DOC21/666127-17

31 August 2021

**Sell and Parker Kings Park Metal Recovery and Recycling Facility Expansion SSD 10396
EPA Advice on Submissions Report**

2 Anthony St, Blacktown

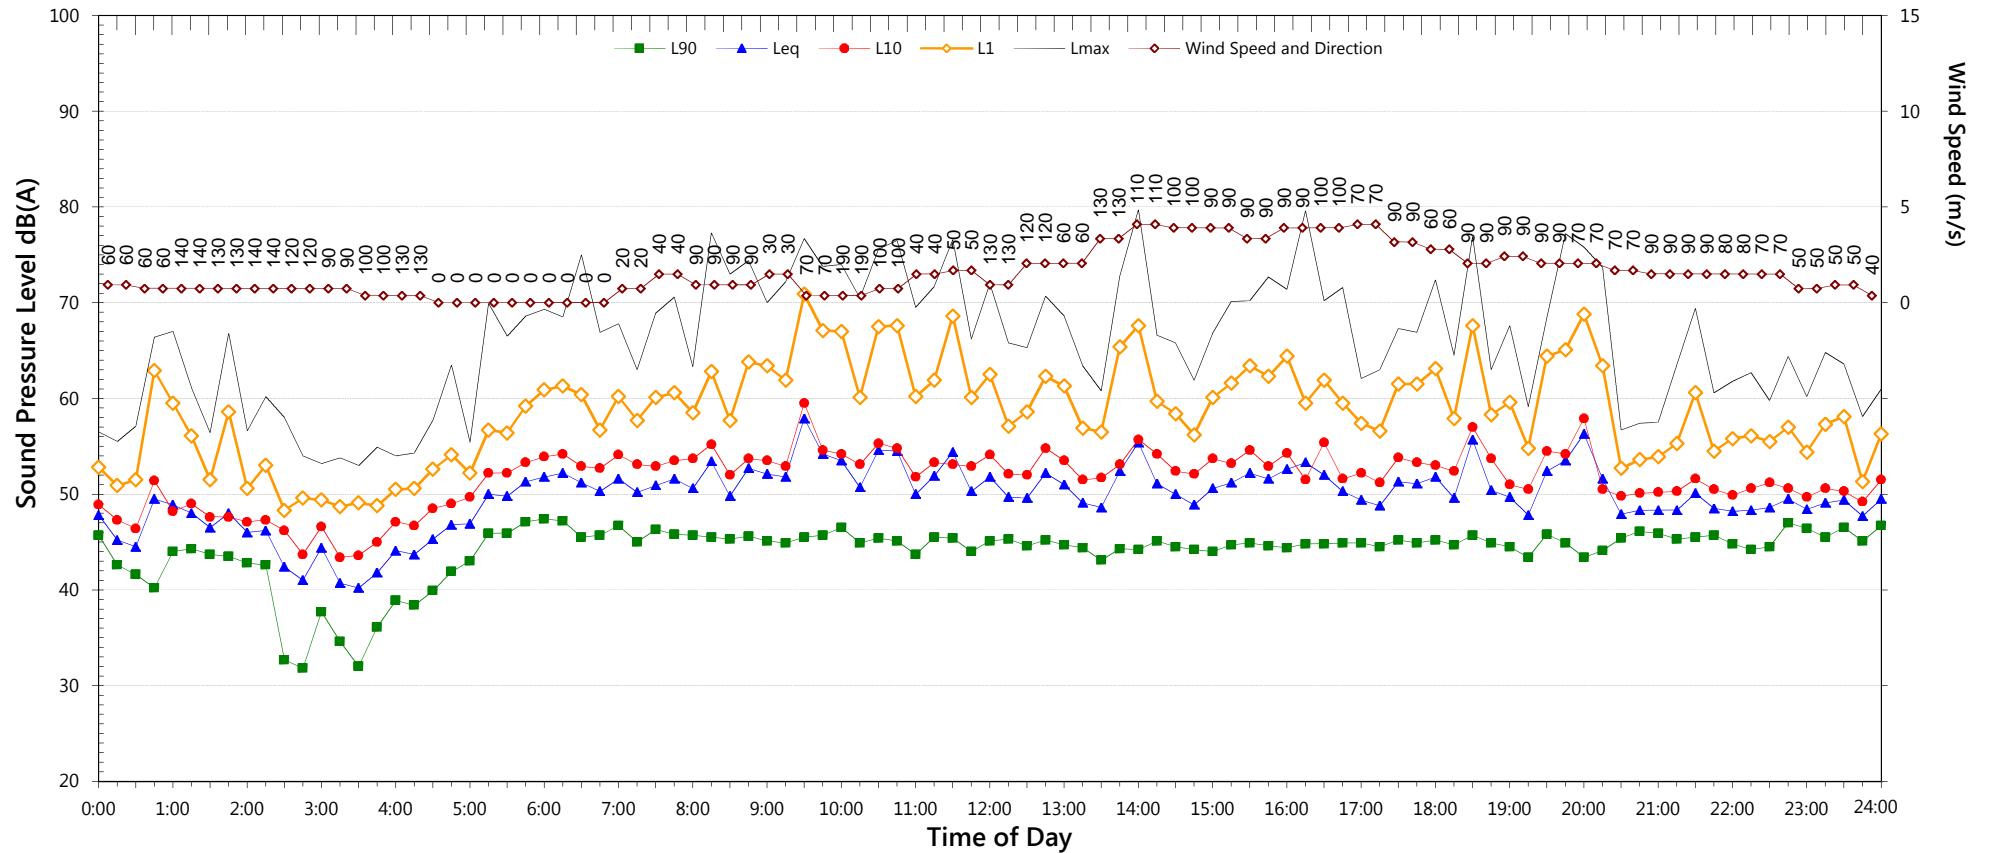
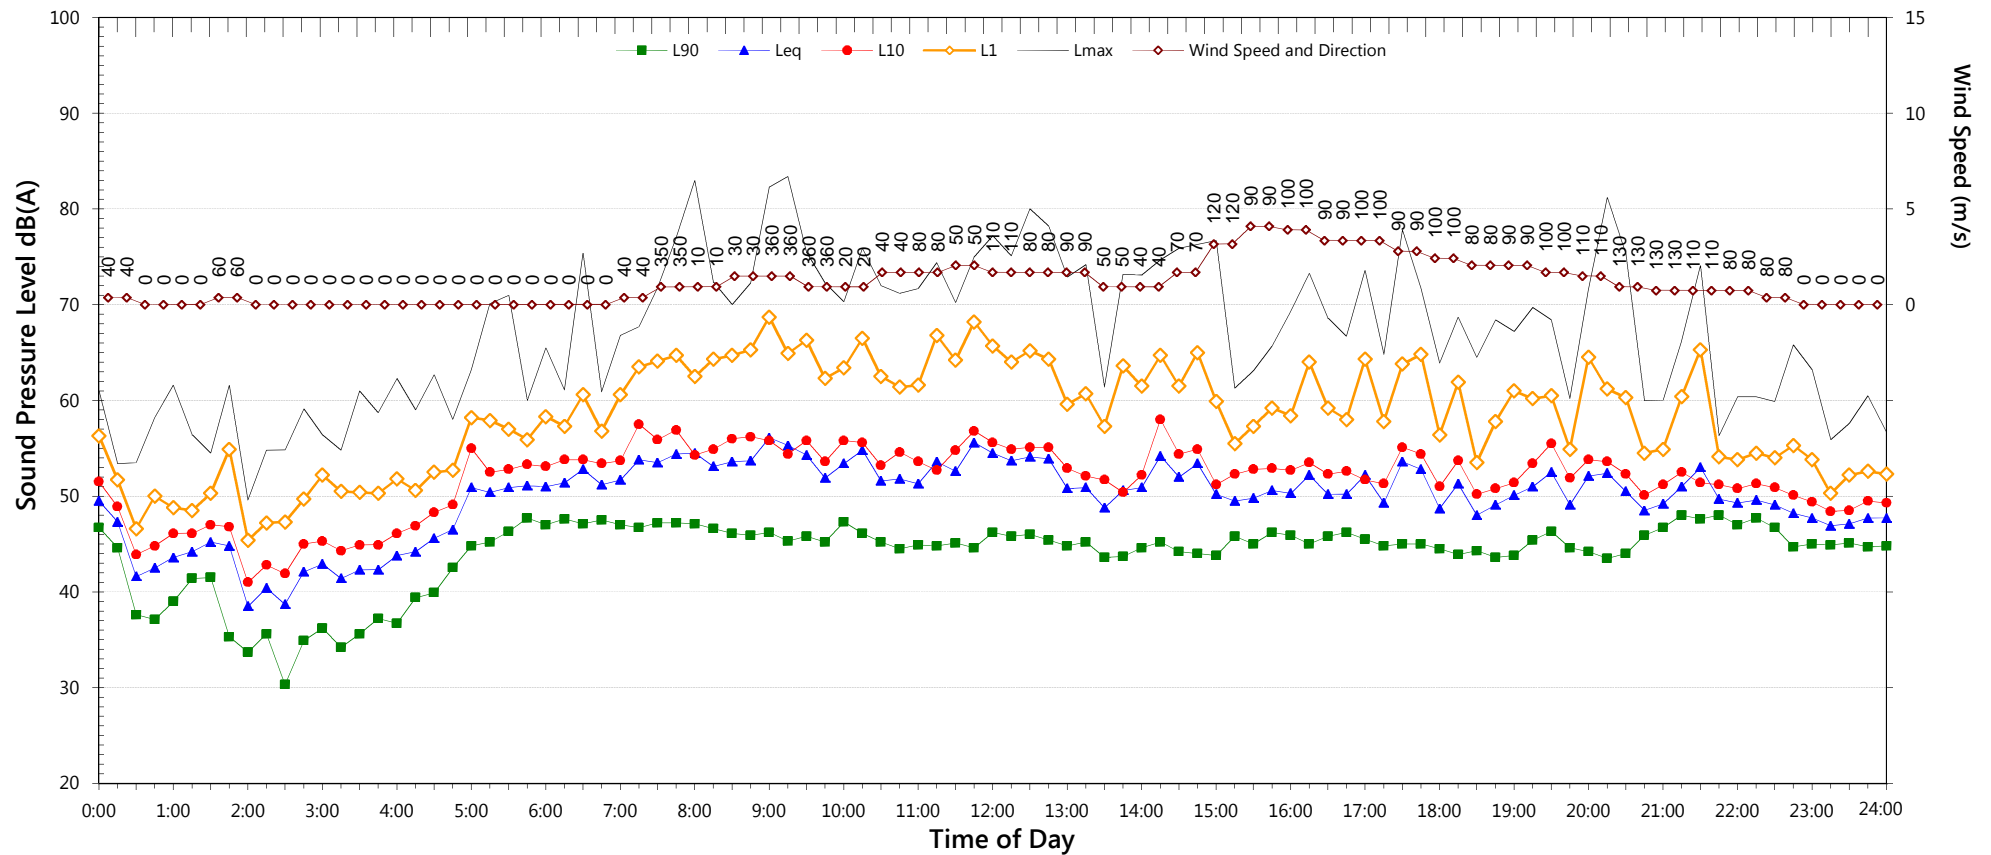
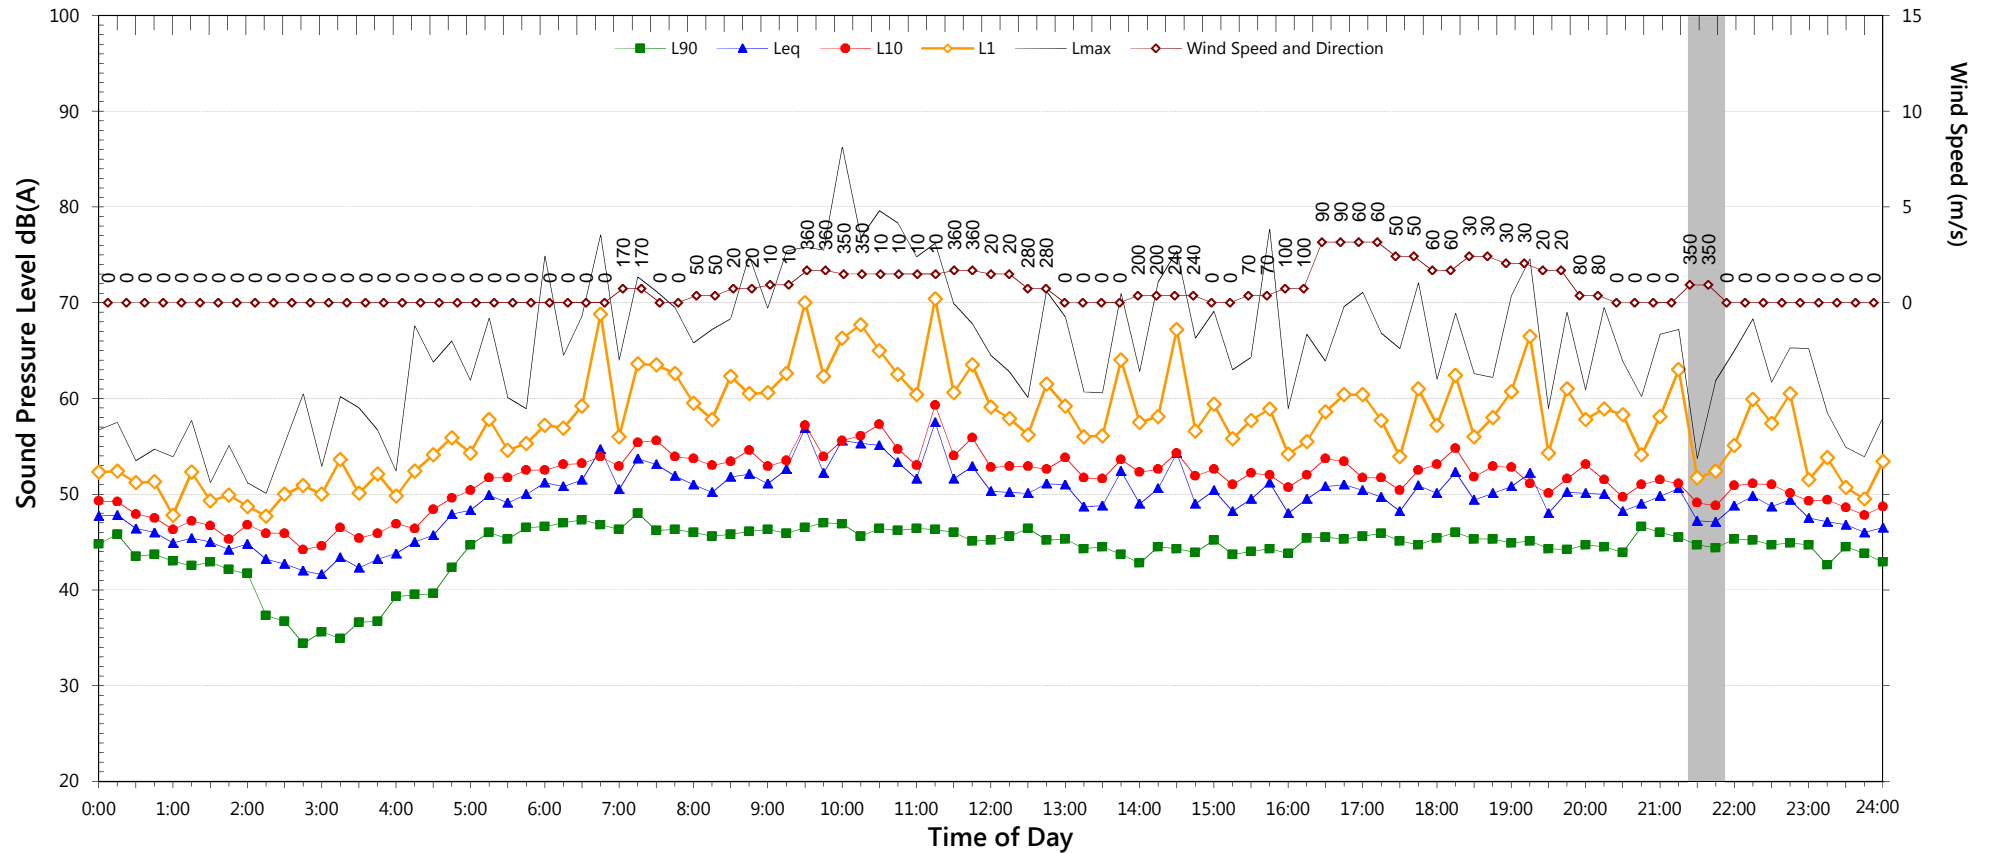
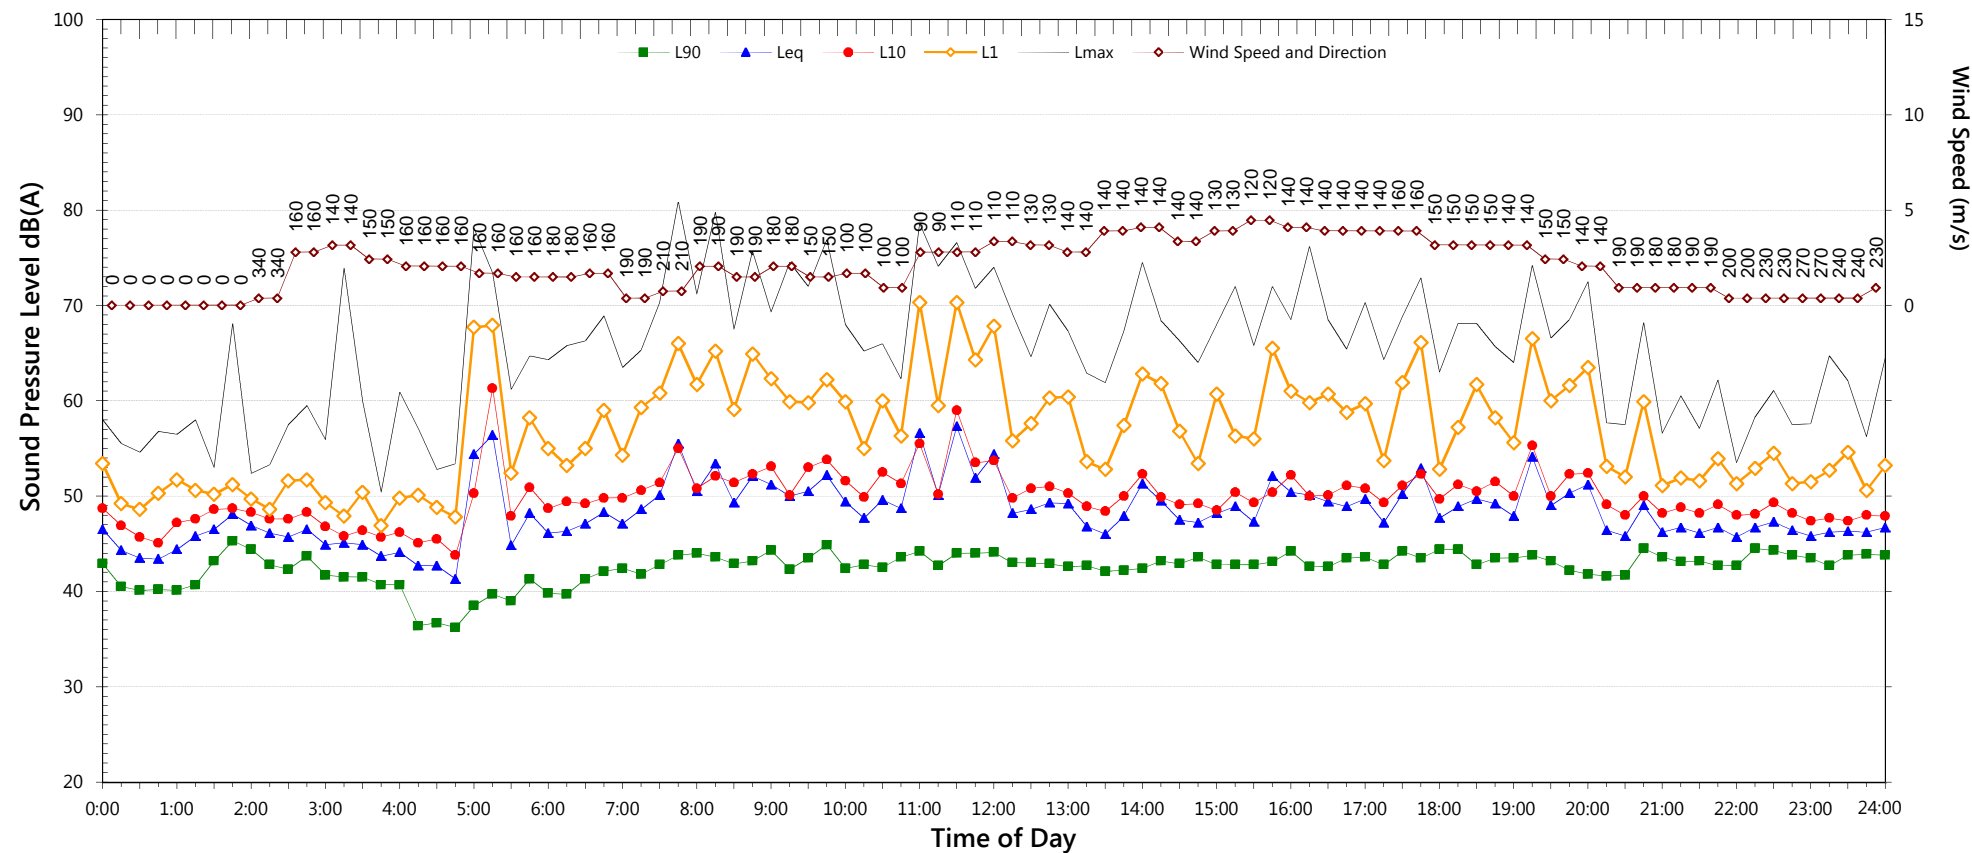
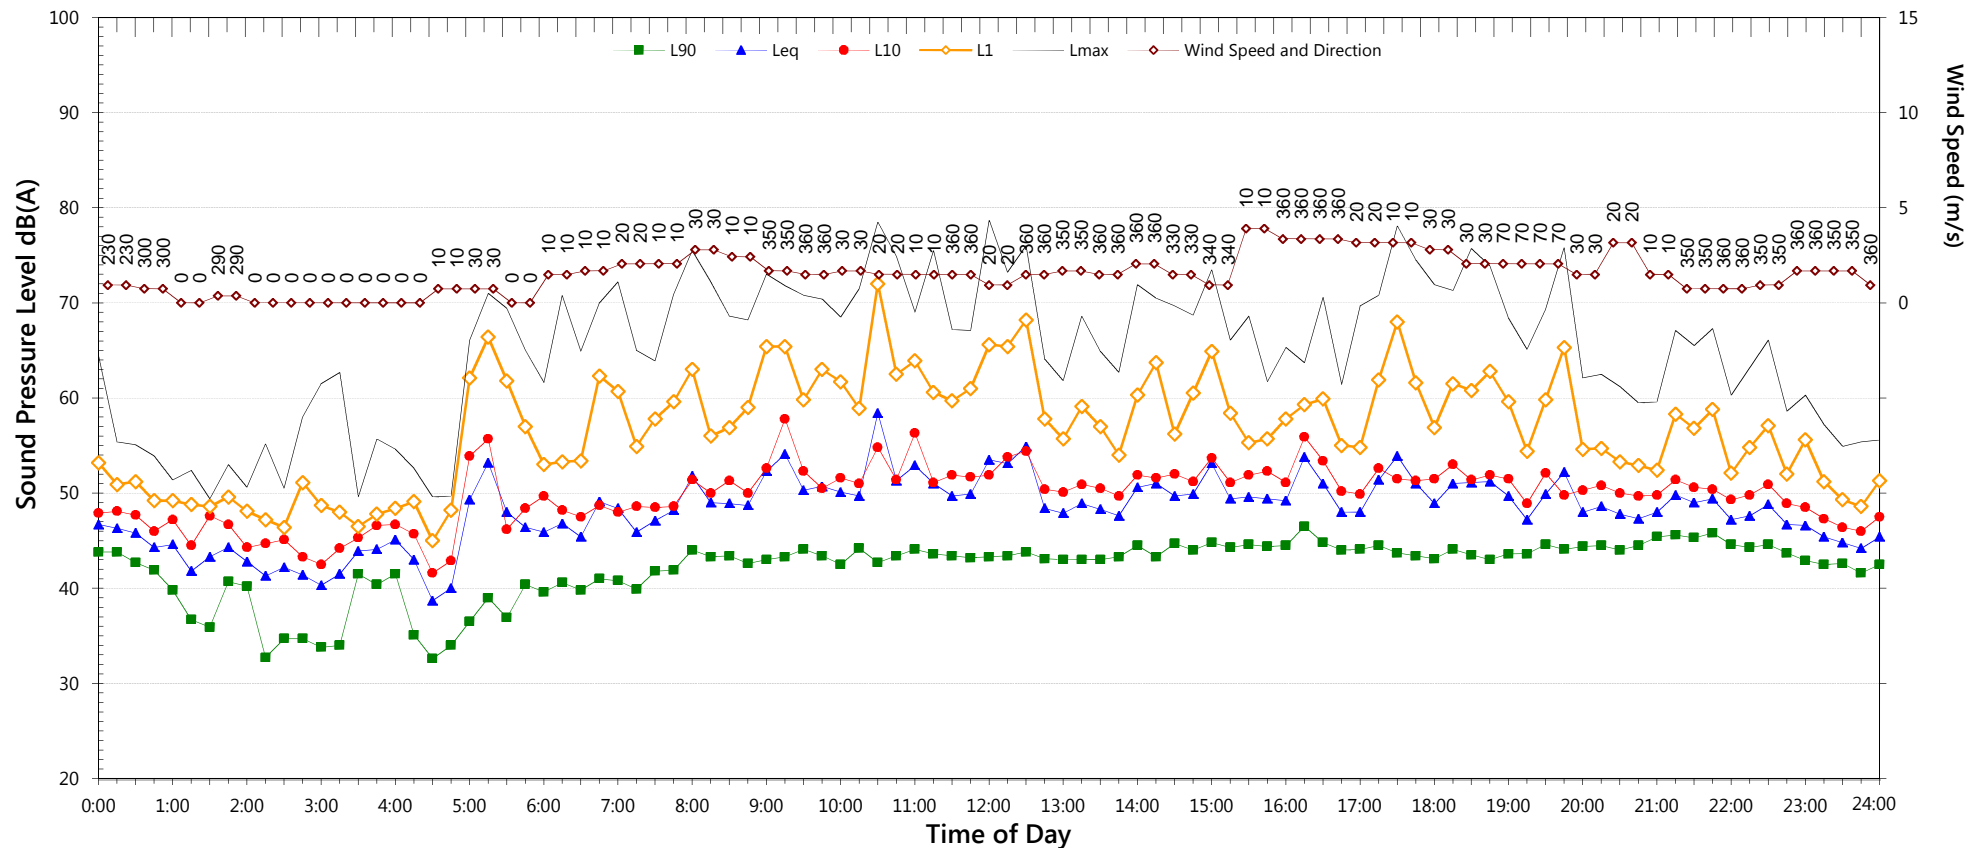
1. The prevailing noise environment for receivers in NCA 1B at an appropriate location further removed from Sunnyholt Road than 2 Anthony Street Blacktown;

<p>There is uncertainty with the noise data used to inform the Project Noise Trigger Levels and sleep disturbance criteria.</p> <p>The EPA does not concur with the Project Noise Trigger Levels and sleep disturbance criteria presented in the assessment due to the issues raised with the characterisation of the existing acoustic environment in the area as outlined in the comments above. The criteria presented in the NIA, Section 6 needs to be reviewed in terms of the issues raised.</p> <p>The proponent must review and confirm, or amend if and as appropriate, the noise data used to inform the Project Noise Trigger Levels and sleep disturbance criteria taking into account the EPA’s comments above.</p>	<p>The Supplementary Noise and Vibration Impact Assessment (refer to Appendix C) has included additional long term noise monitoring at four locations between 11 February and 24 February 2021. This long-term noise monitoring was used to determine the Rating Background Levels (RBL) and representative ambient noise levels in accordance with the NSW ‘Noise Policy for Industry’ (NPfl). The project noise trigger Levels and sleep disturbance criteria have been updated based on the more recent monitoring data. In consideration of the updated project noise trigger Levels and sleep disturbance criteria, including prevailing meteorological conditions, noise emissions for all receivers comply with relevant project noise trigger levels without any additional noise mitigation measures.</p> <p>Nonetheless, as part of the commitment to continuous improvement and to reflect comments provided within community submissions, Sell &</p>	<p>See comments above regarding concerns about the background noise monitoring undertaken for NCA 1B and NCA 2.</p> <p>Additionally, the project amenity noise level derived in the Supplementary NIA adopts “urban” residential noise amenity area. The zoning of all residential locations is R2 which according to the NPfl, Table 2.3 would attract a “suburban” residential noise amenity area.</p> <p><u>The selection of “urban” needs to be justified.</u> Any justification needs to consider ambient noise levels and sources, and in the case of NCA1B the ambient environment of locations further removed from Sunnholt Road (i.e. not 2 Anthony Street).</p>
